Flood Management & Drainage Consultation - LEAD LOCAL FLOOD AUTHORITY – Statutory Consultee

Consultation on Application Number: 2017/94019

Address: Land off, St Mary's Avenue, Netherthong, Holmfirth, HD9 3XN

**Proposal: Discharge conditions 4, 7, 9, 11, 12, 13 on previous permission
2014/91533 for outline application for erection of residential development**

Project
**ST MARY'S AVENUE
NETHERTHONG**
Title
**CONTROL MANHOLE DETAIL
SW1.7**

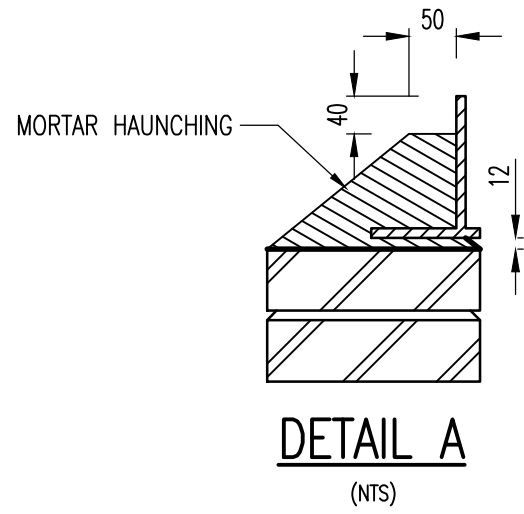
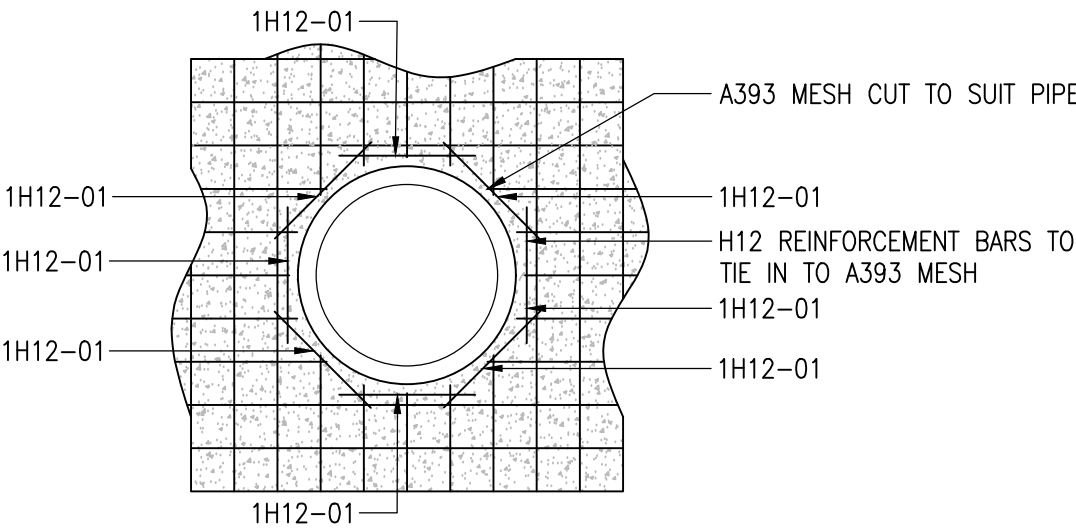
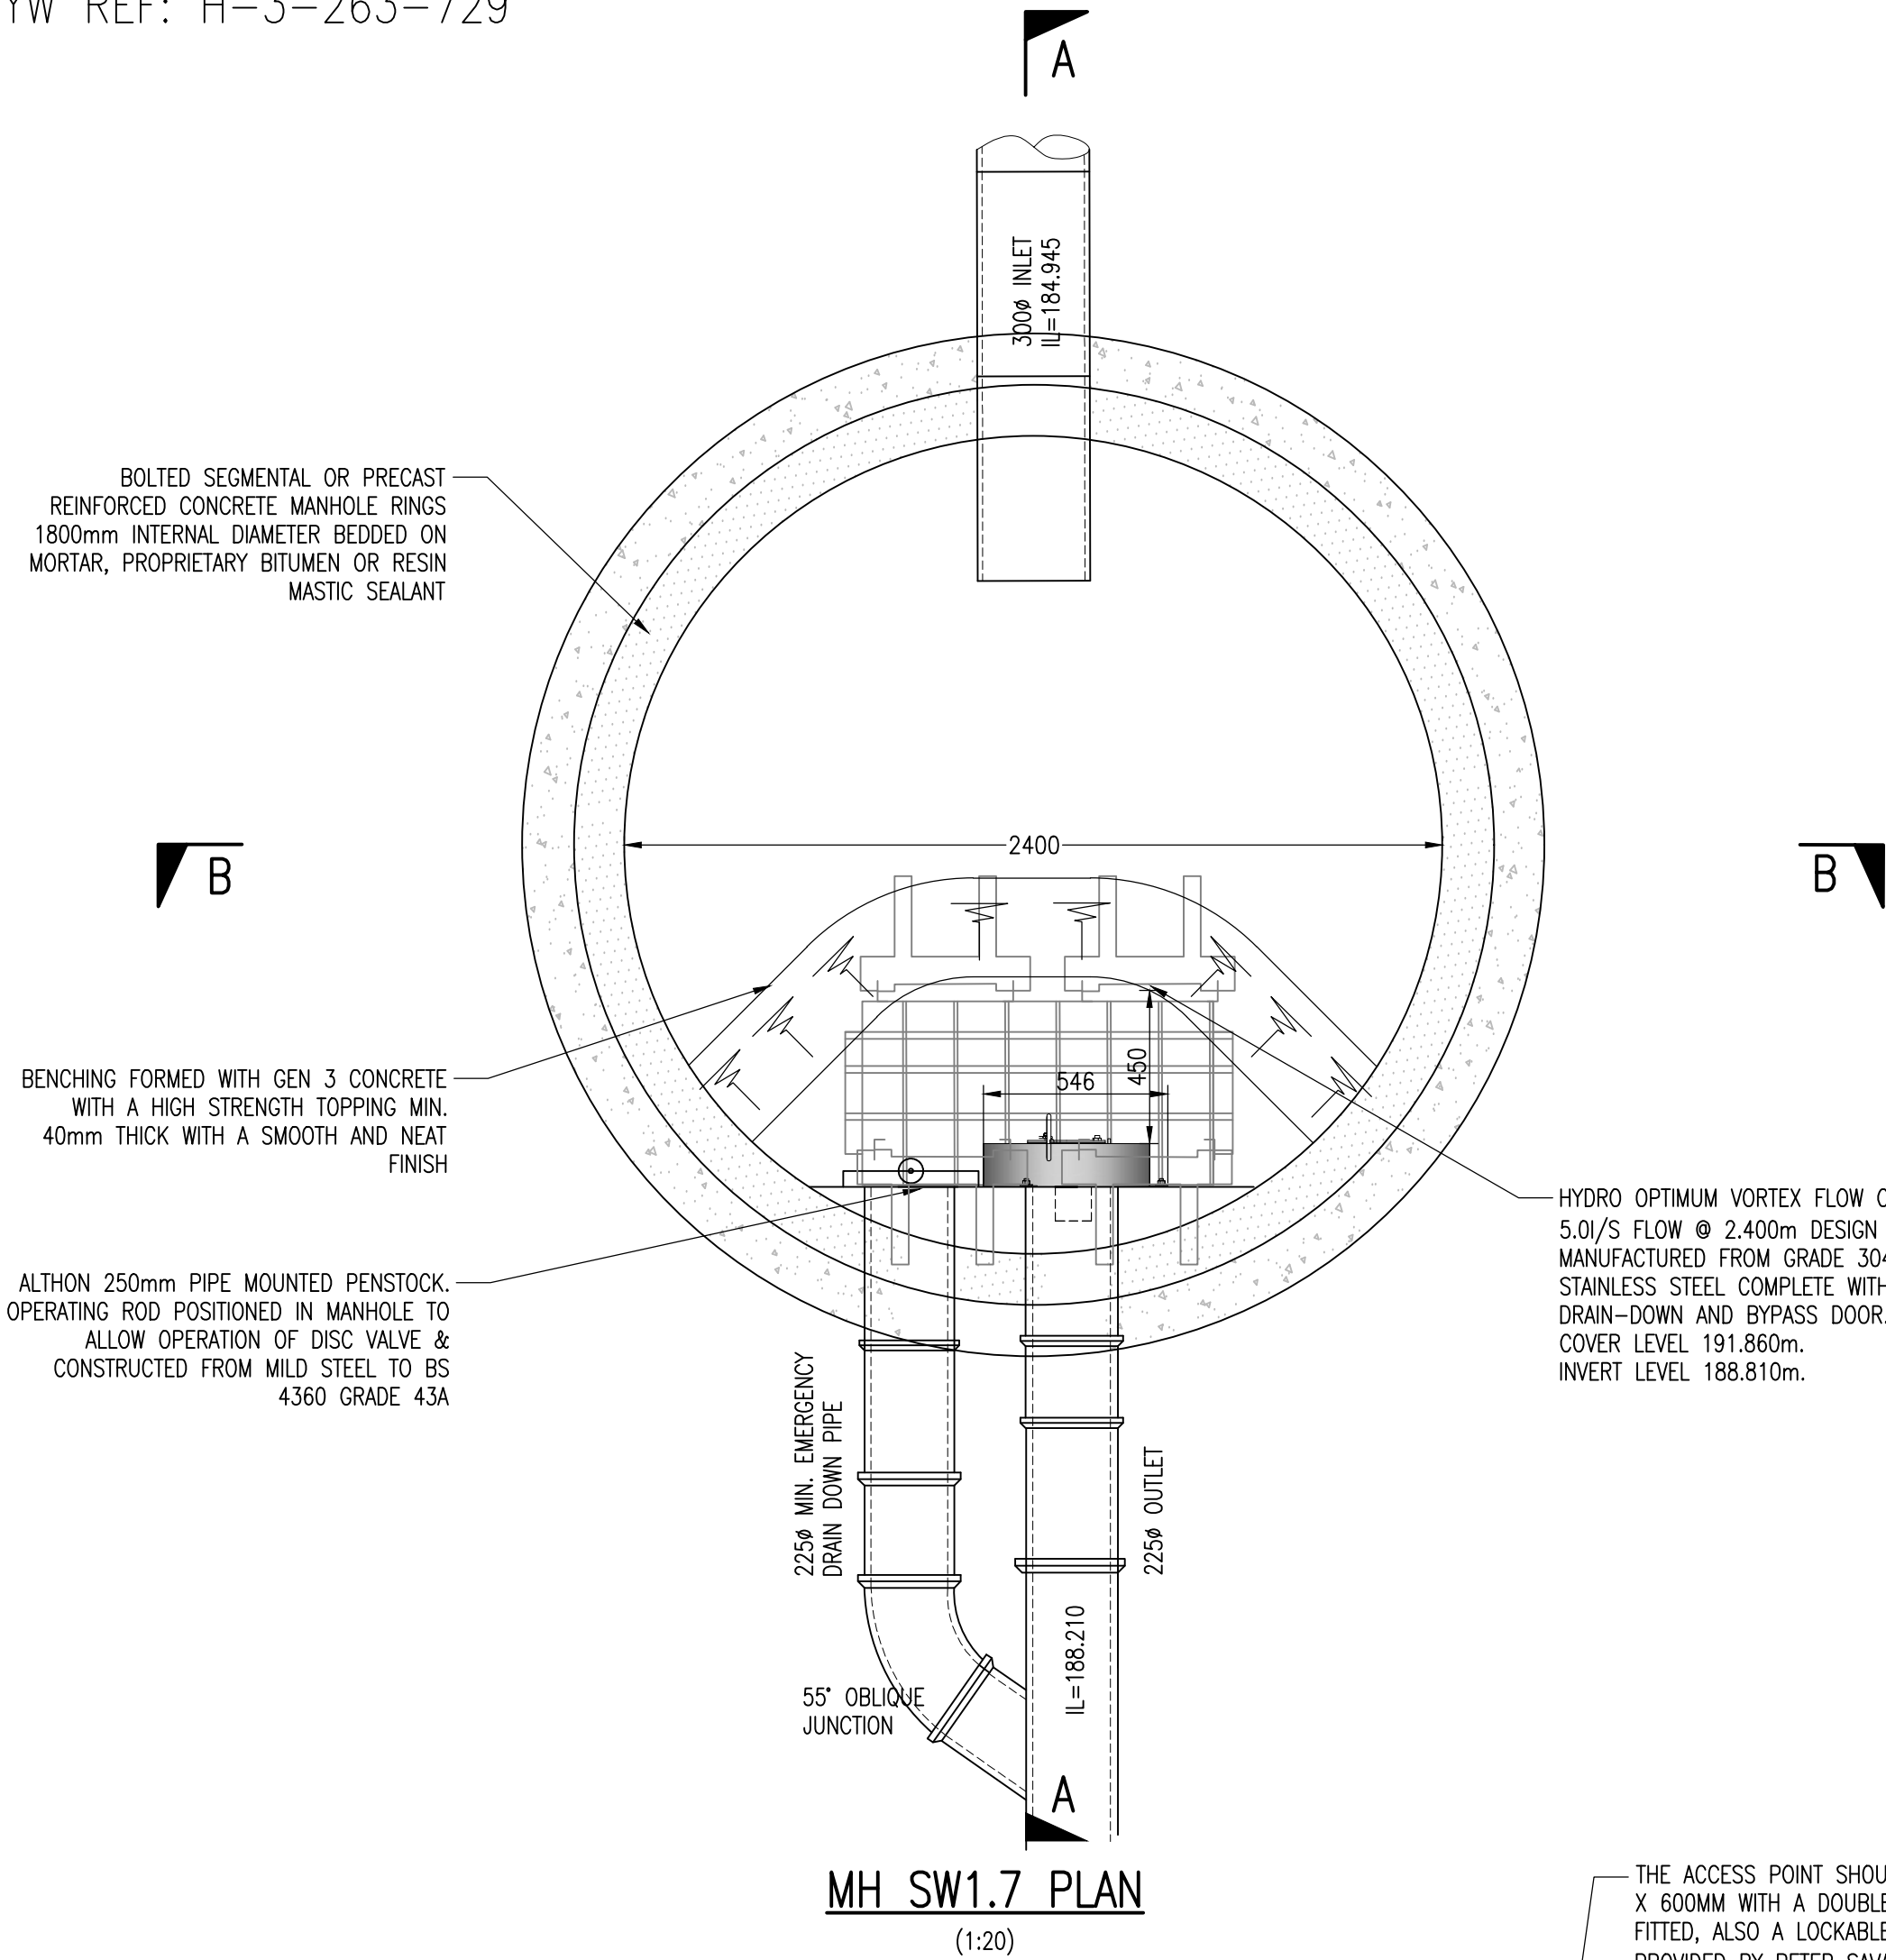
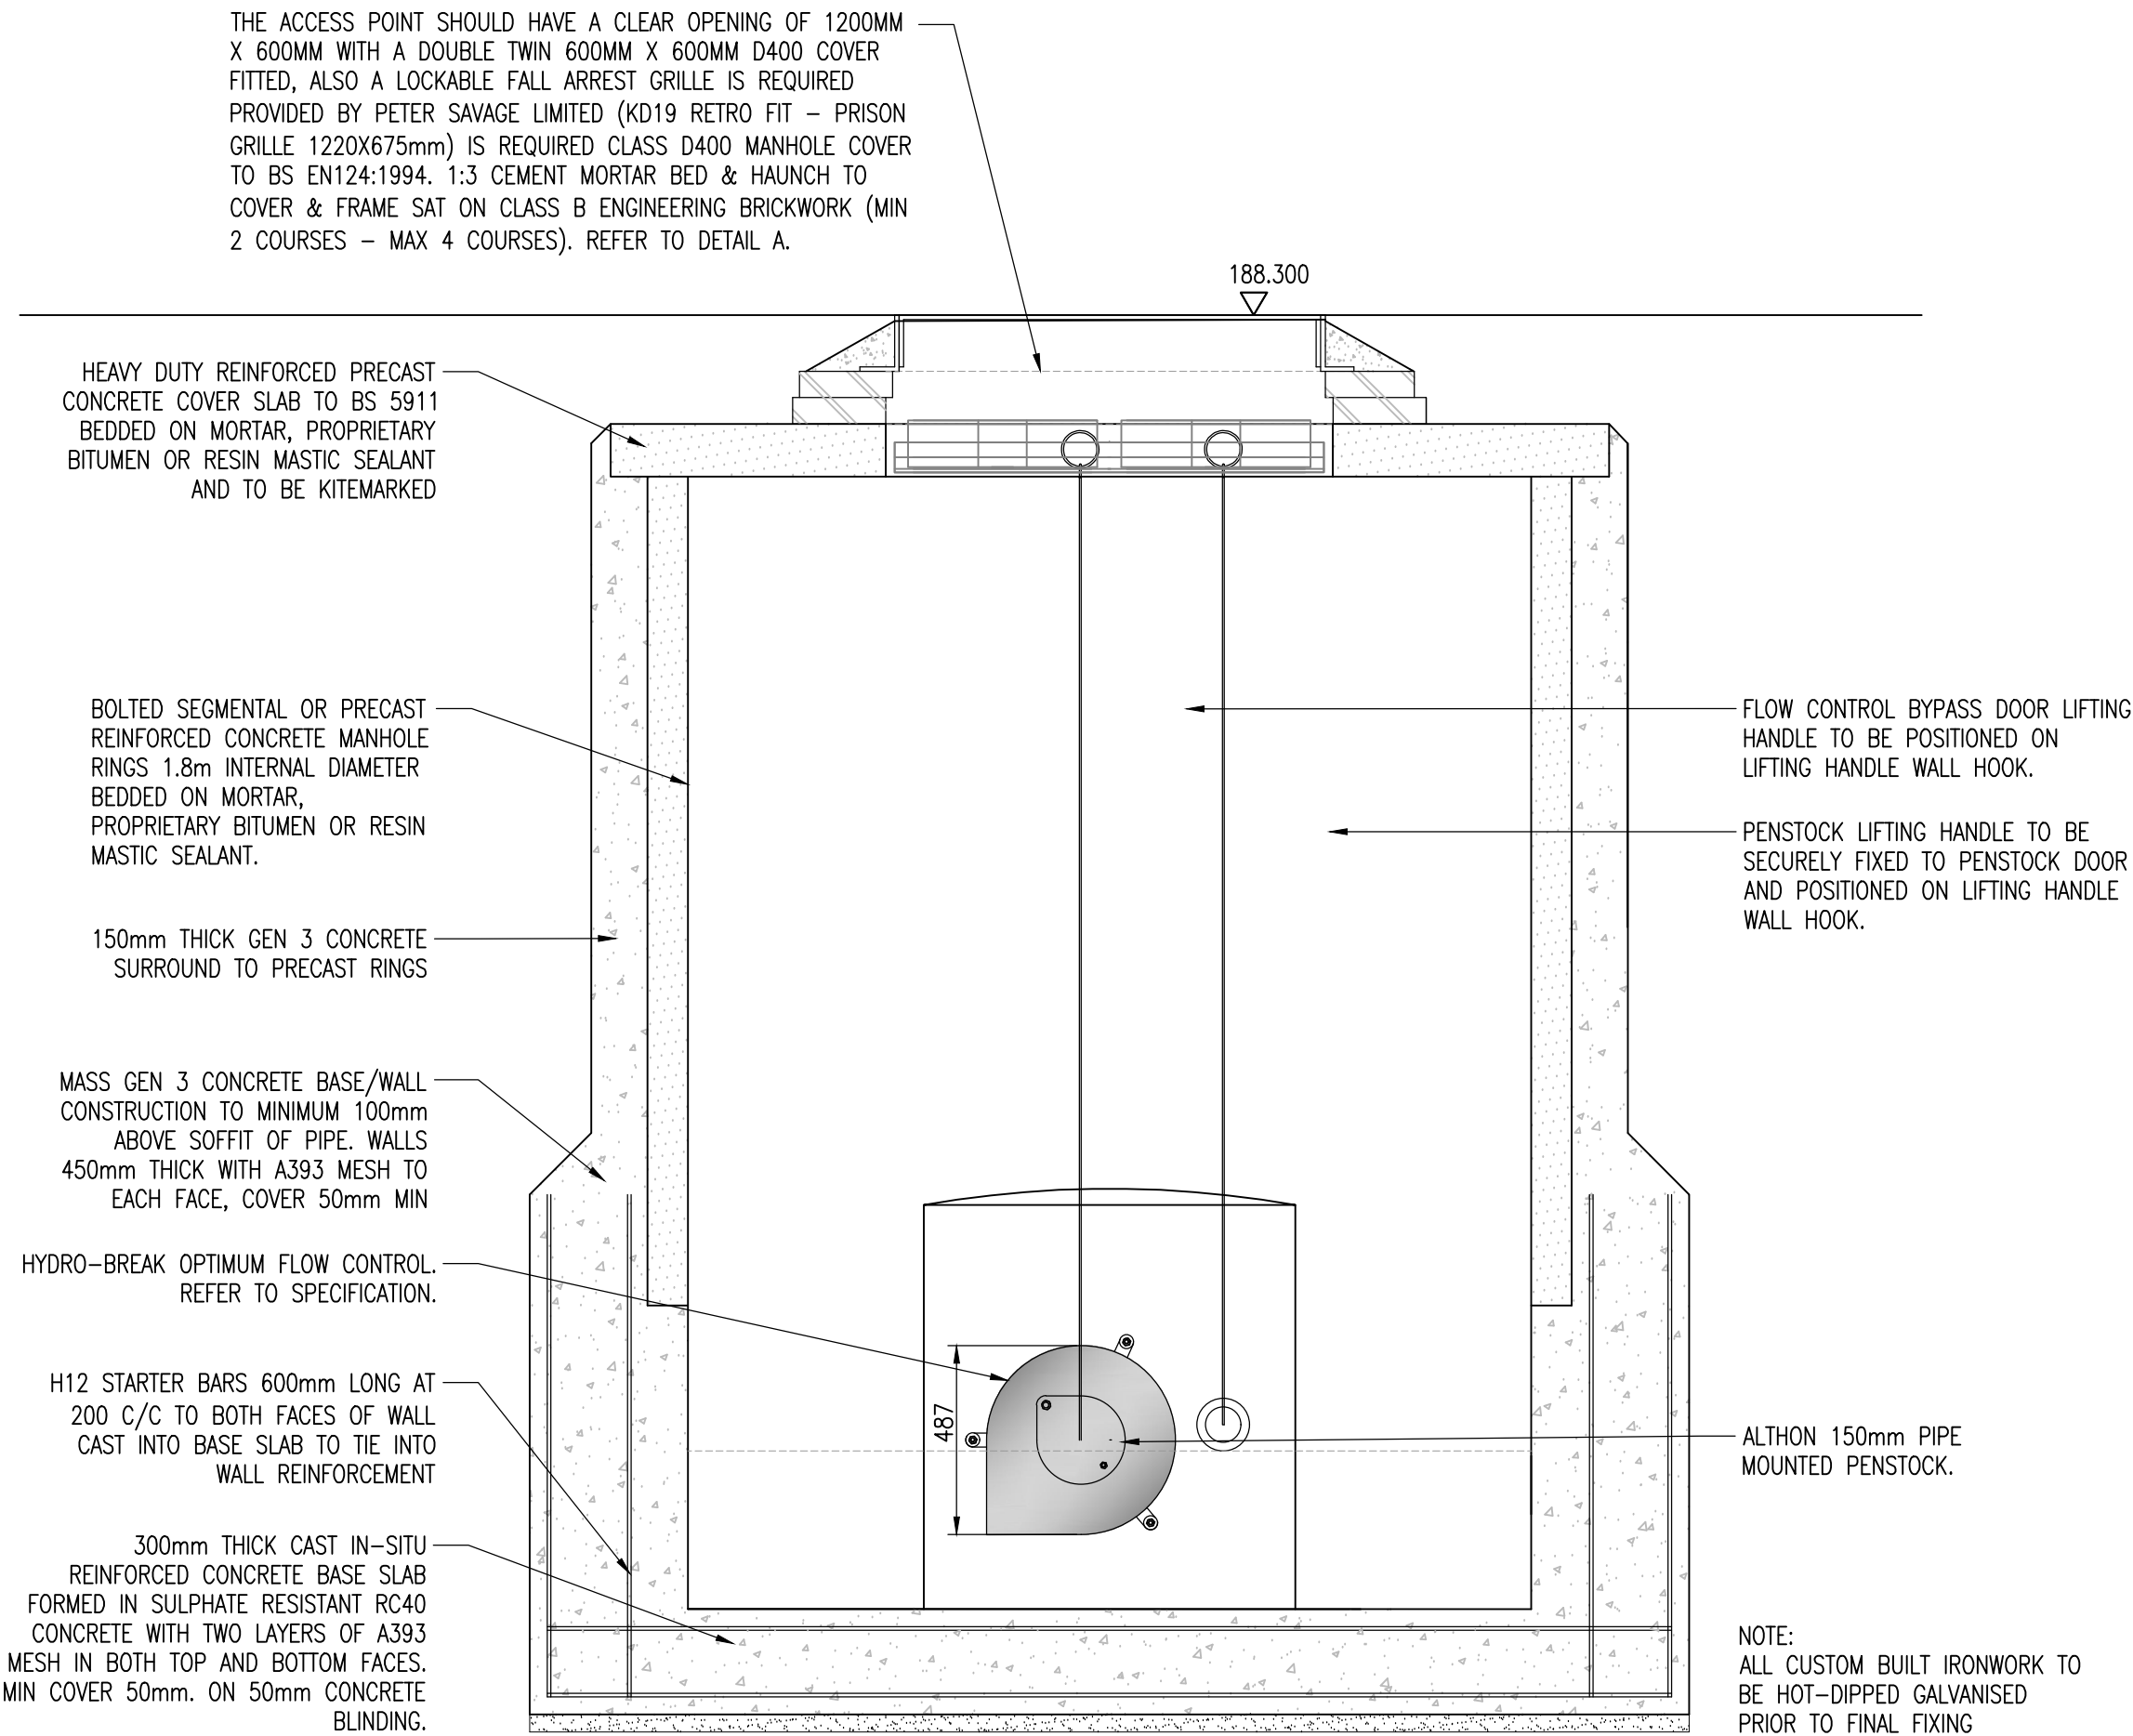
The attenuation submitted is shown not to flood in the 1 in 100+ climate change event.
